RE: Responses to Pre-Application Comments  
White Barn Brown Bear Carwash  
8833 Soper Hill Road, Marysville, Washington  
City File No. 23005  
Our Job No. 22681

## **Pre-Application Conference – Response to Comments**

# OPEN SPACE PLAN

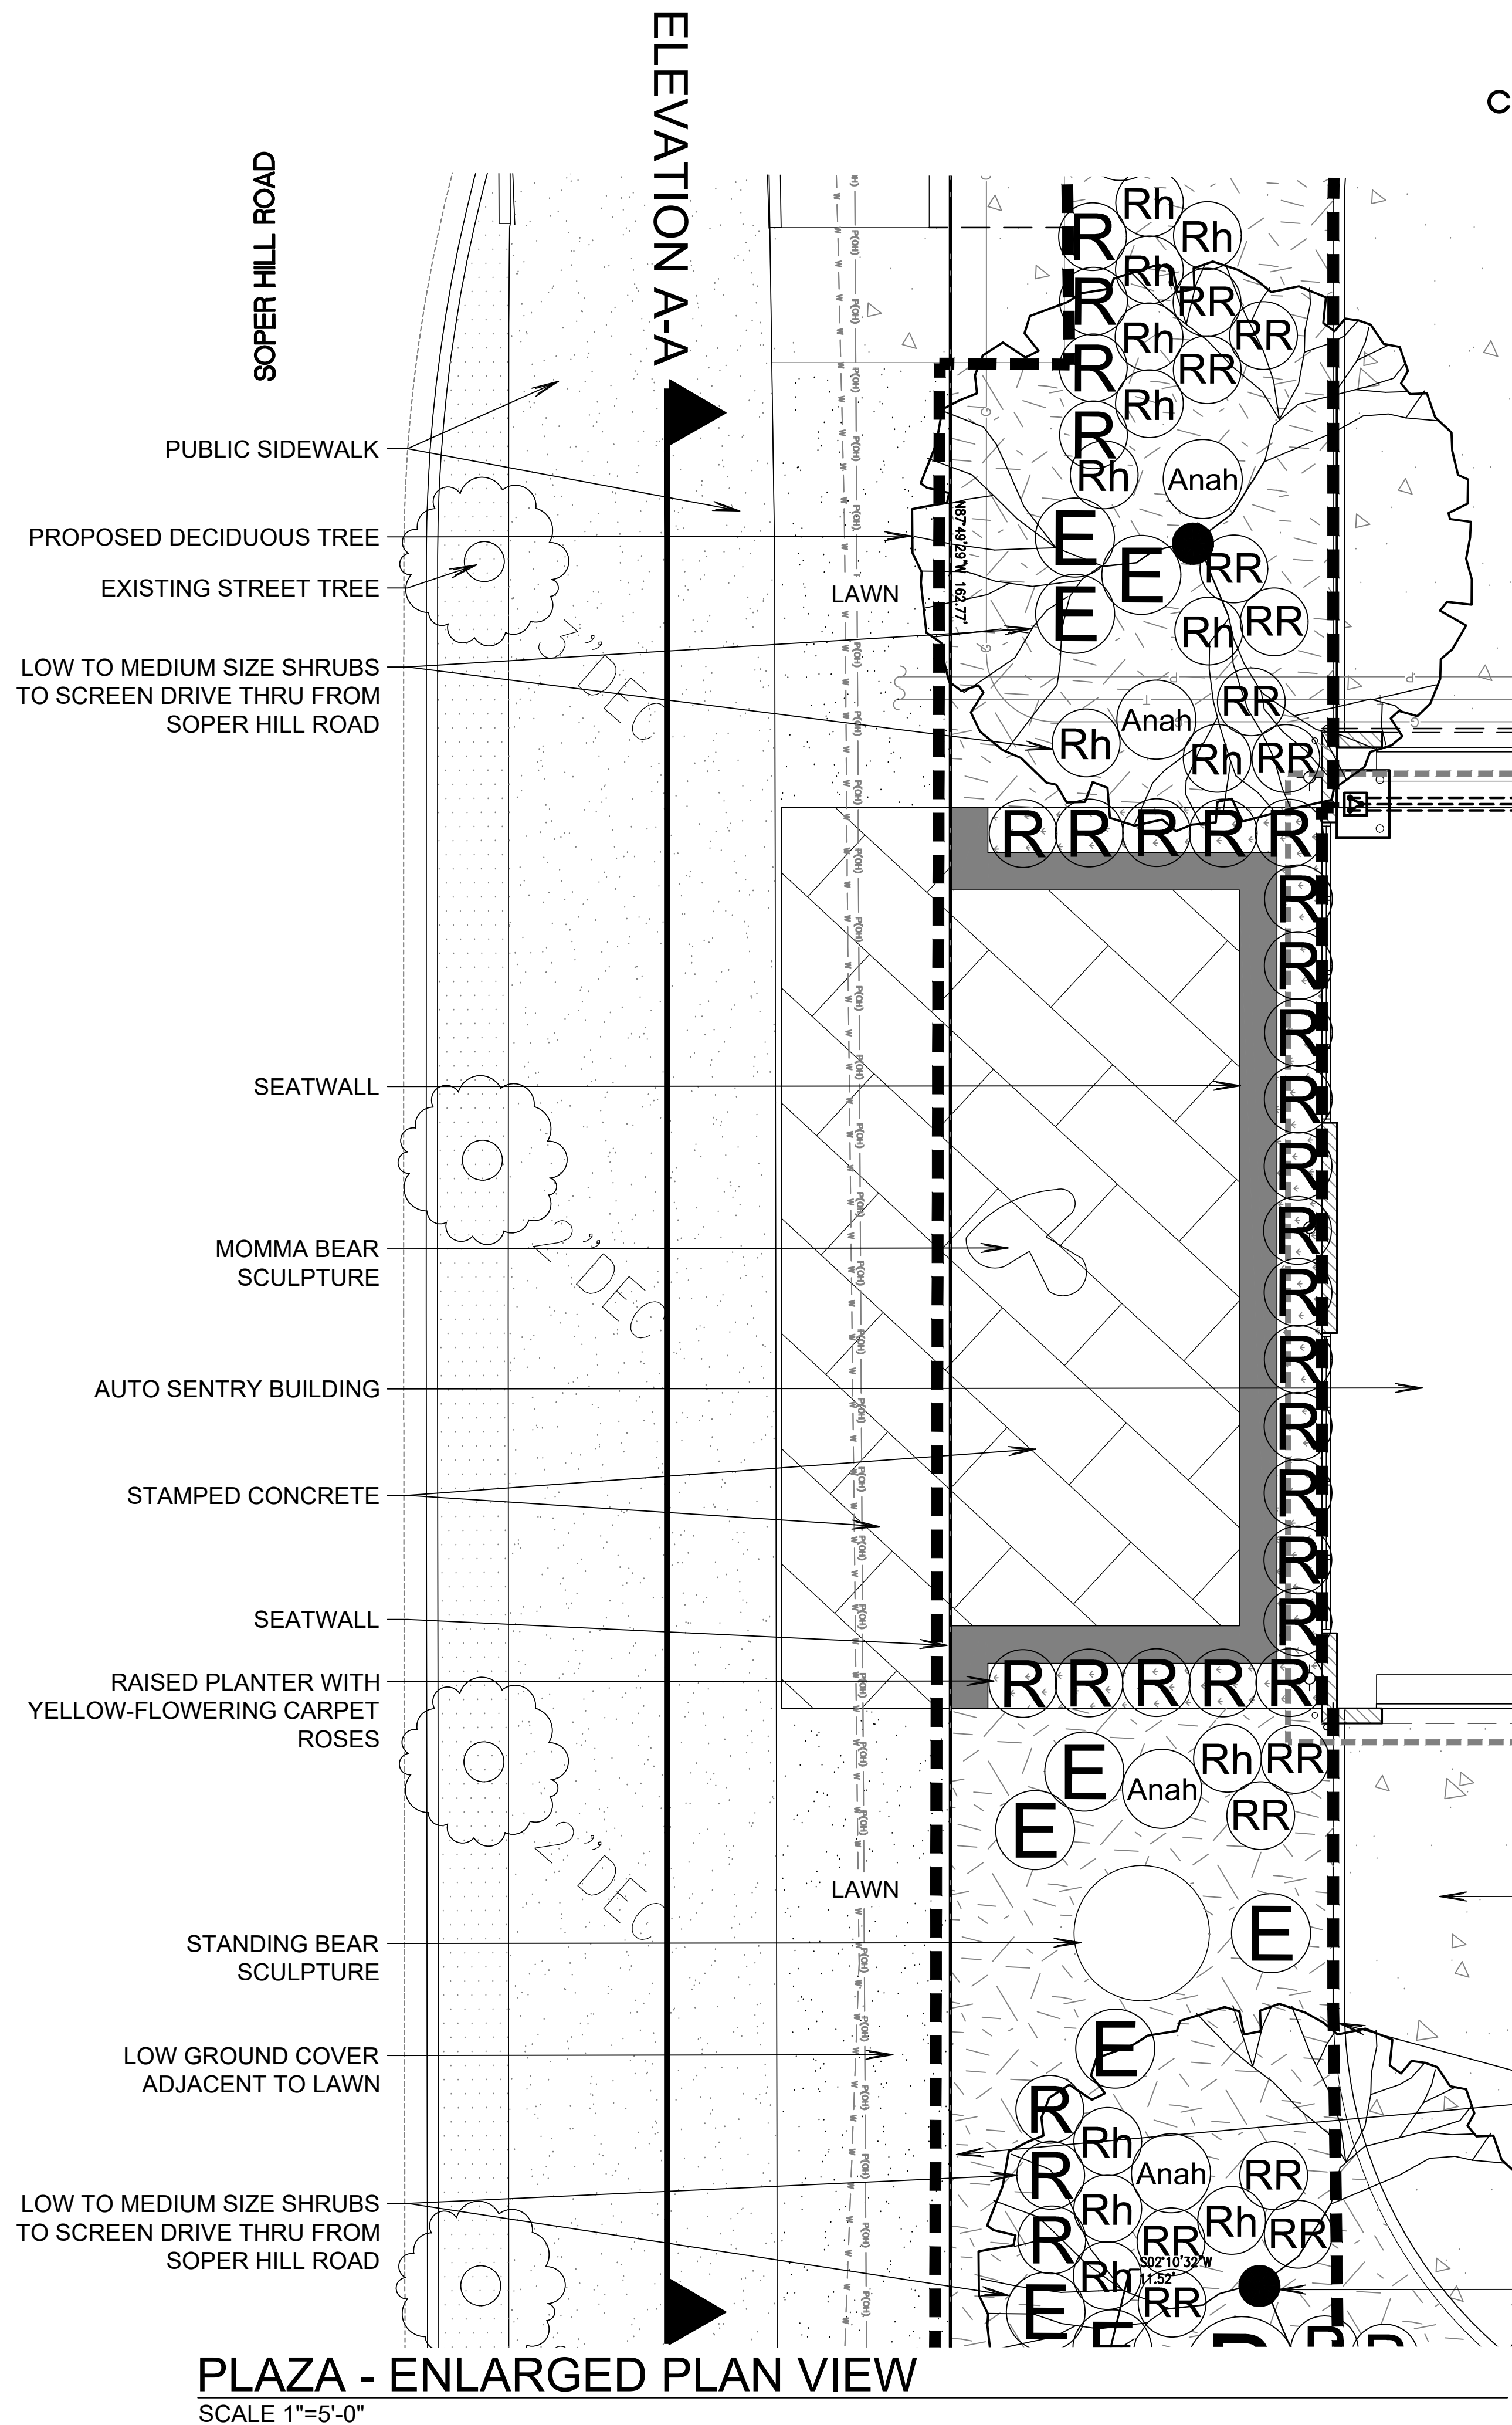
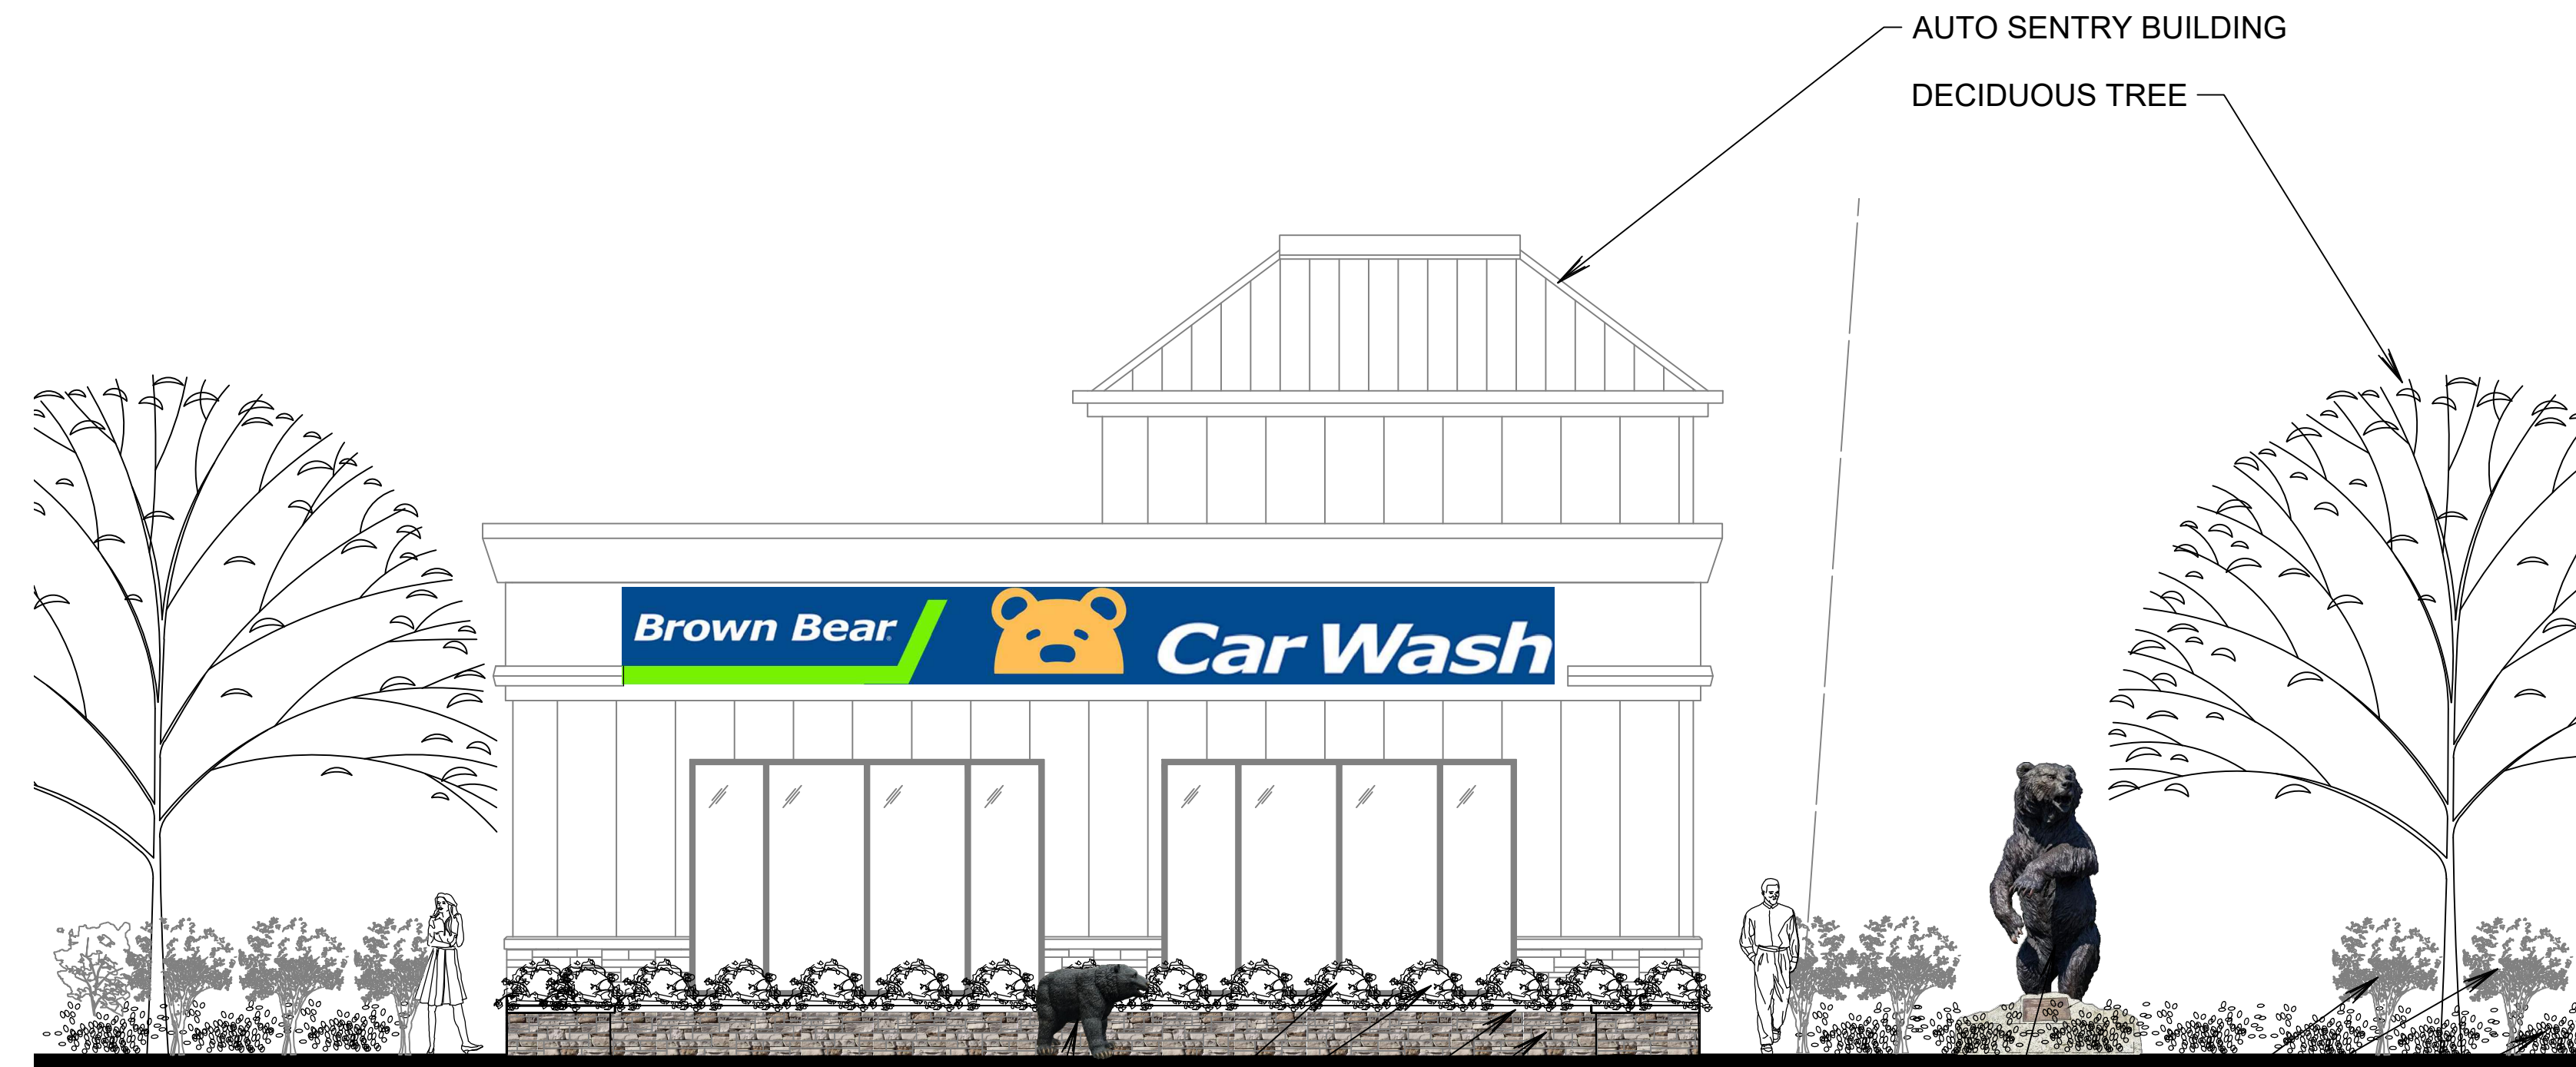
- c. *MMC 22C.070.100(2)(b): Open Space for Non-Residential Uses. Non-residential uses shall provide pedestrian-oriented space, defined in subsection (2)(c) (see design standards for qualifications), at a rate of 2% of the site, plus 1% of the building floor area. Required sidewalks and walkways shall not count as pedestrian-oriented space.*

**Response:** Provided. Please see sheet C1.0 and L1 for details on the Pedestrian-oriented space.
